# CITY OF ALBUQUERQUE

April 19, 2016

**Re: Eclectic Restaurant Renovation**  
**2119 Menaul Blvd. NE**  
Traffic Circulation Layout  
**Architect's Stamp Date: 4/8/2016; H16D002**

DATE SUBMITTED: _____ By: _____

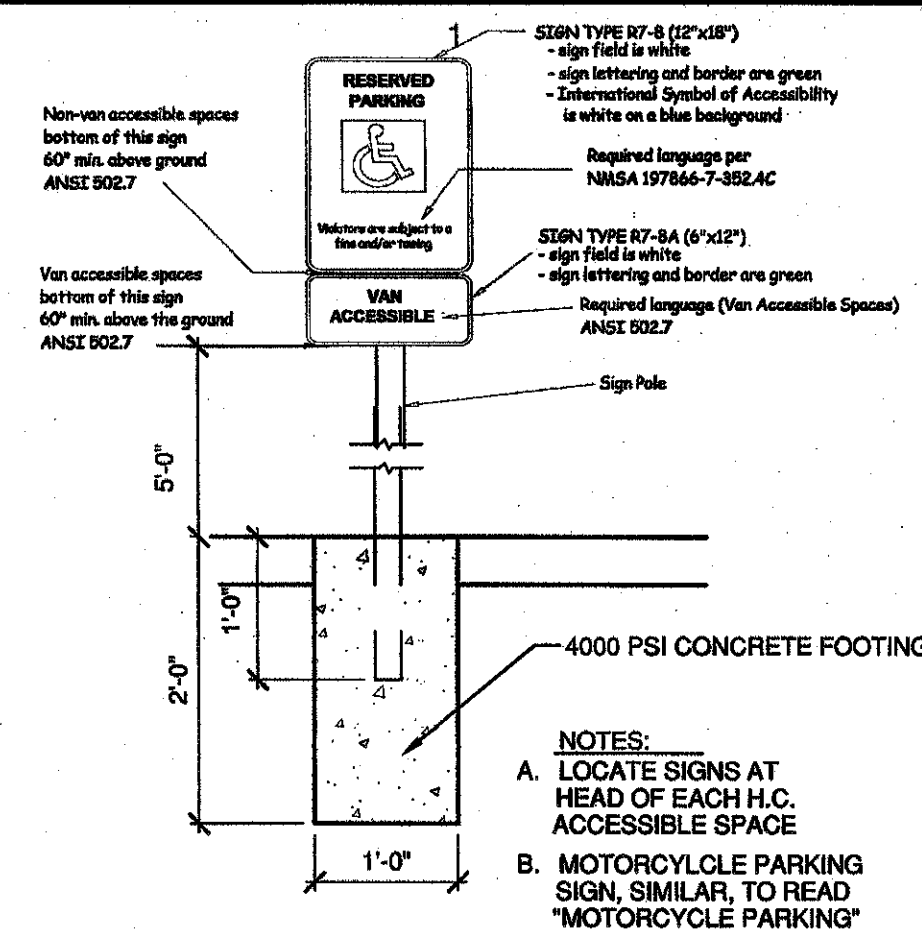
3. Identify the width of the curb cut adjacent to Menaul Blvd.
4. The ADA accessible parking sign must have the required language per 66-7-352.4C NMSA 1978 **"Violators Are Subject to a Fine and/or Towing."** Please call out detail and location of HC signs.

5. The ADA access aisles shall have the words **"NO PARKING"** in capital letters, each of which shall be at least one foot high and at least two inches wide, placed at the rear of the parking space so as to be close to where an adjacent vehicle's rear tire would be placed. (66-1-4.1.B NMSA 1978)

10. Please specify the City Standard Drawing Number when applicable, for example, new sidewalk, new accessible ramp (Keyed Note 16), etc.
11. Is the accessible ramp (Keyed note 16) proposed or existing? If existing, does it meet ADA design standards?
